Planning reference: 3/2024/0996

Location : 98 Ribchester Road and land adjacent 94 Ribchester Road, Clayton-Le-Dale, BB1 9HQ

Proposal : Approval of details reserved by conditions 9 (SW drainage), 12 (drainage scheme)

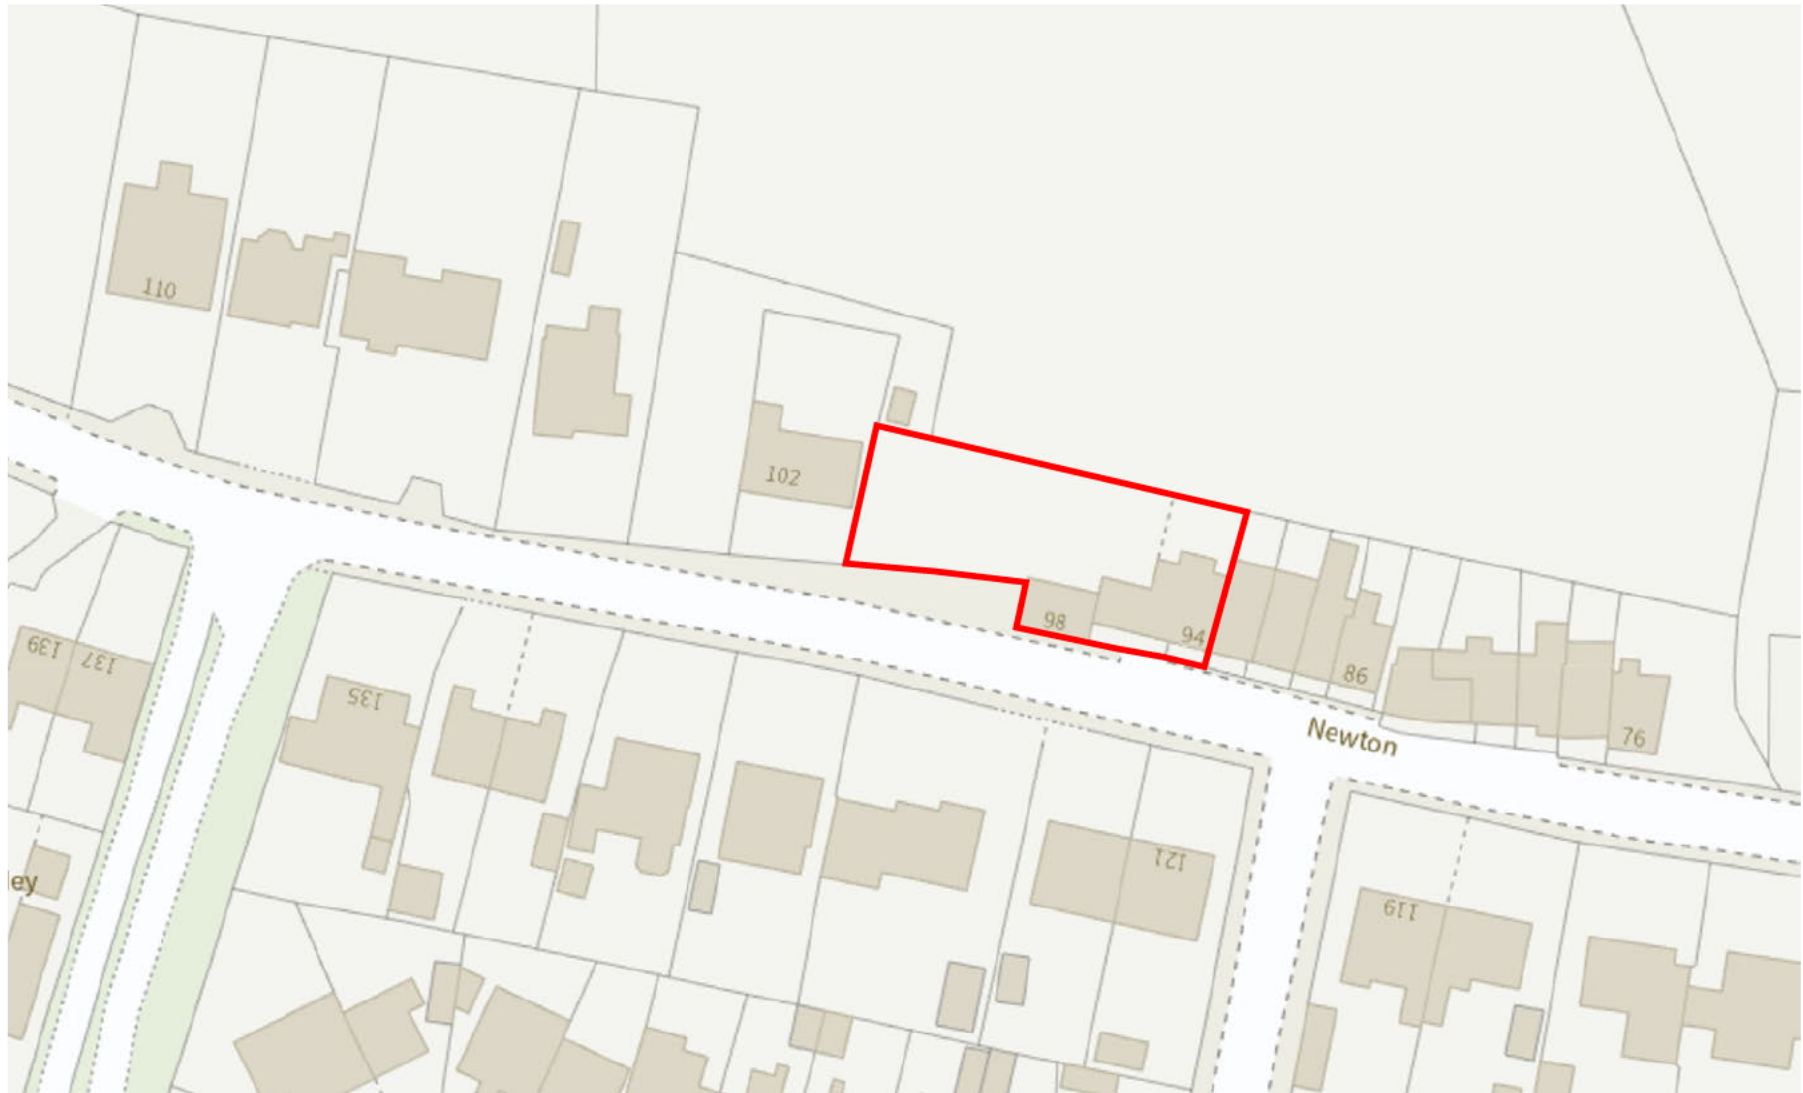
1. It is unclear how the connection is being made with the public wastewater network. We require a detailed drainage plan; clearly demonstrating how the scheme would connect to the public sewer. Noting that this is an application to discharge drainage conditions, we would expect the invert levels and cover levels to be included on the drainage plan.

Response: The drainage plan that was included within the surface and foul water drainage scheme report that was produced in support of the application to discharge the drainage conditions has been revised to provide the information requested above and is attached to this letter.

A drainage survey has been carried out on the drainage within and immediately beyond the development site. It has been proved that the drain leaving the development site under the existing access is connected to the public sewer that lies within Ribchester Road into an

existing manhole that is hidden under the road surfacing. The existing connection enables discharges to be made from the existing site and will be used to enable discharges from the proposed development.

EXISTING DRAINAGE

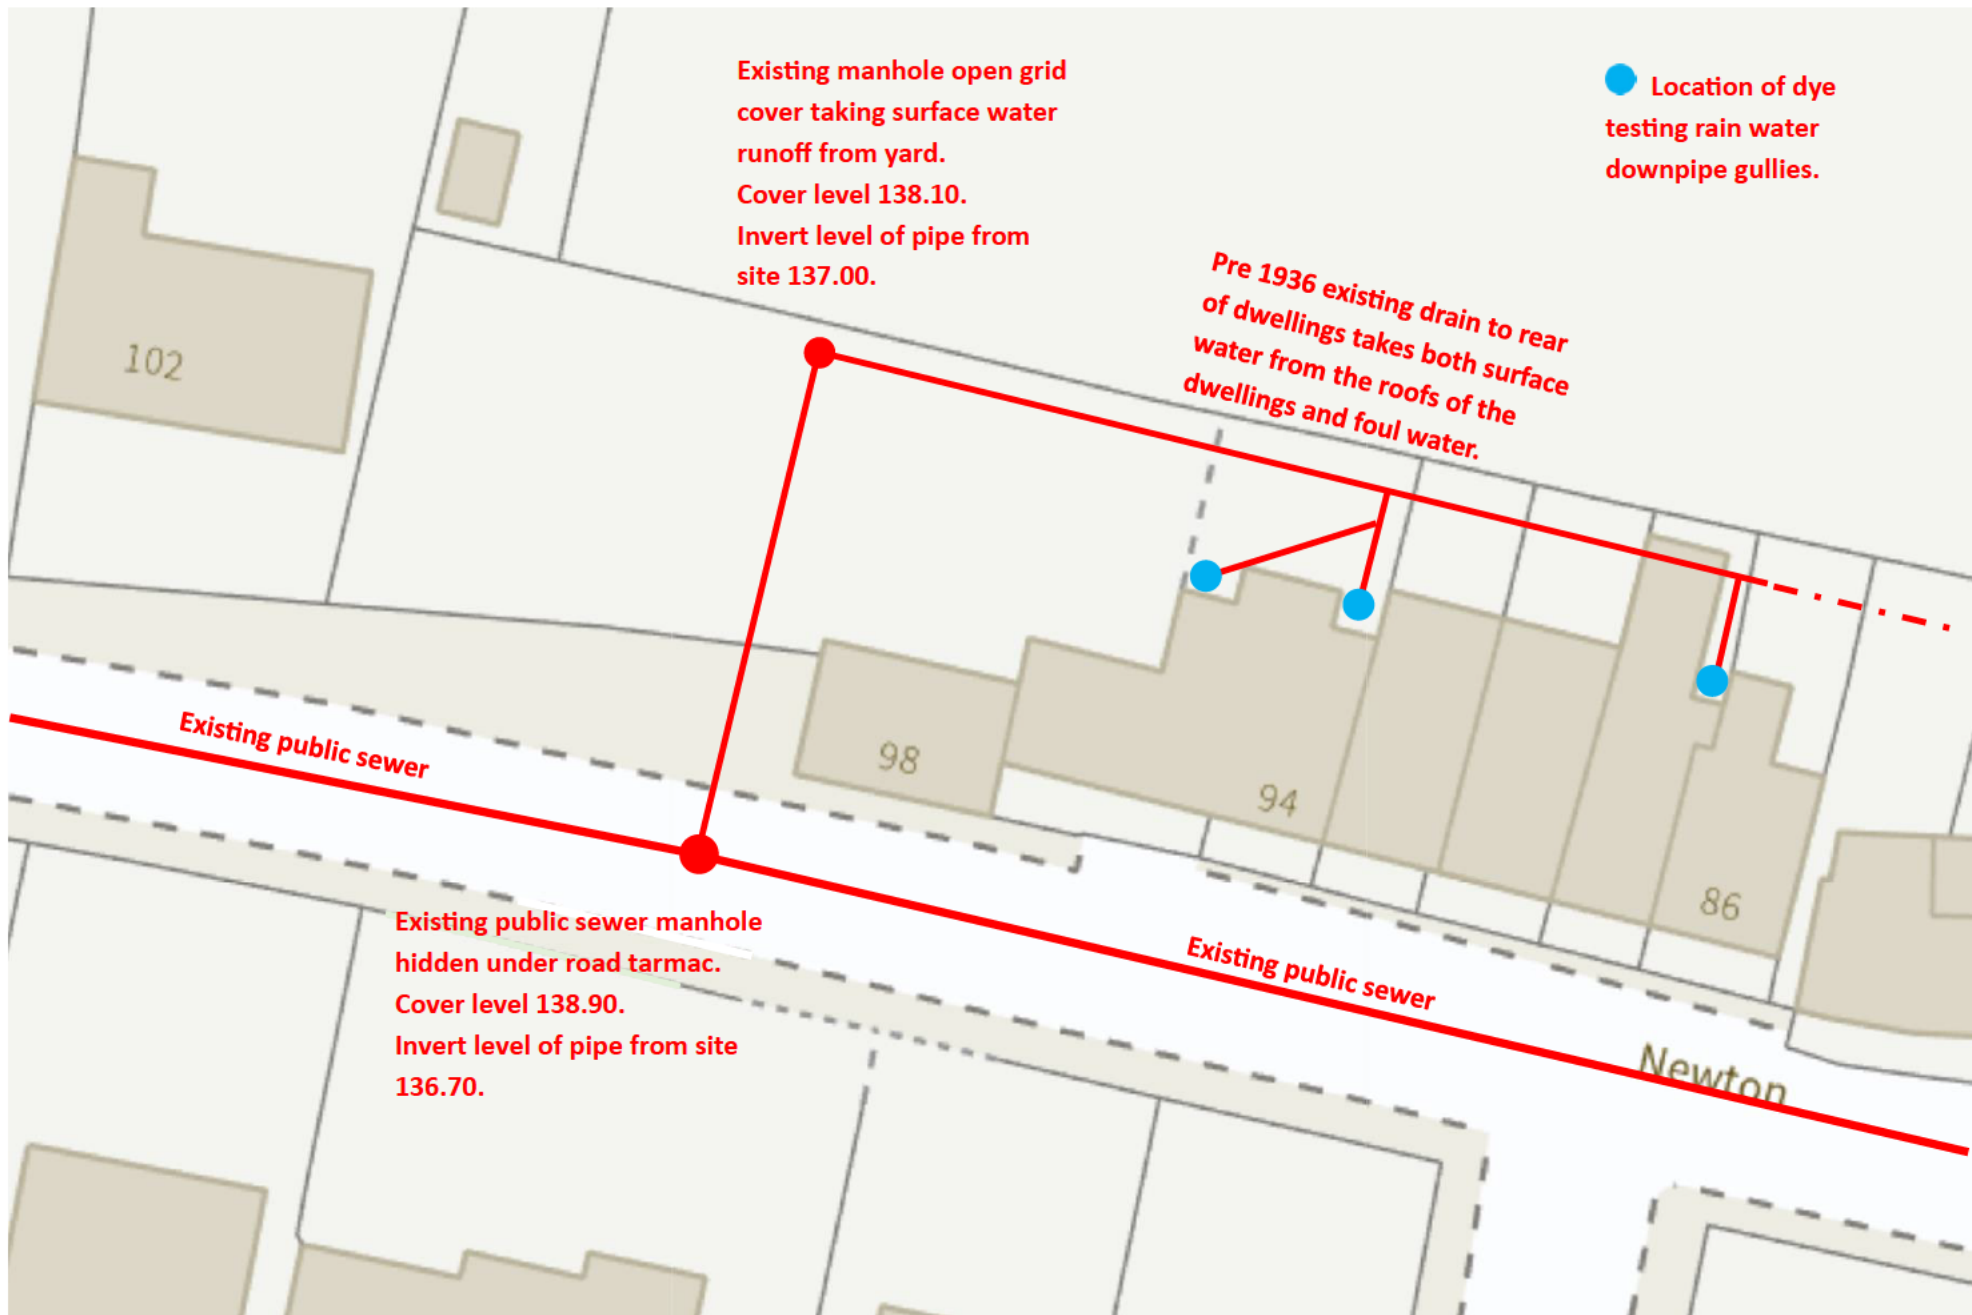
2. The sewer shown on our records is being assumed to be a combined sewer. The asset maps indicate it is a foul only sewer. We require evidence i.e. a drainage survey, to confirm that the foul sewer we have on our records is in fact a public combined sewer.

Response: A drainage survey has been carried out of the drainage within and beyond the application site. The result of the survey is shown on the existing drainage plan attached to this letter.

The drainage within the site extends beyond the site to the east of the site and serves the properties to the east that front onto the northern side of Ribchester Road. Dye testing has been carried out on the gullies taking rainwater from the roofs to the rear of the properties and it has been proved that the drain running along the rear of the existing properties takes both surface and foul water from the existing properties.

As stated above in response to item 1 above, it has been proved that this drain, leaving the development site under the existing access, is connected to the public sewer that lies within Ribchester Road into an existing manhole that is hidden under the road surfacing. As such, the public sewer within Ribchester Road is actually a combined sewer as it is taking both surface water and foul water from the existing properties that lie along the northern side of Ribchester Road. Therefore, under the hierarchy for dealing with surface water runoff from development sites, it is acceptable for surface water runoff to be discharged into it.
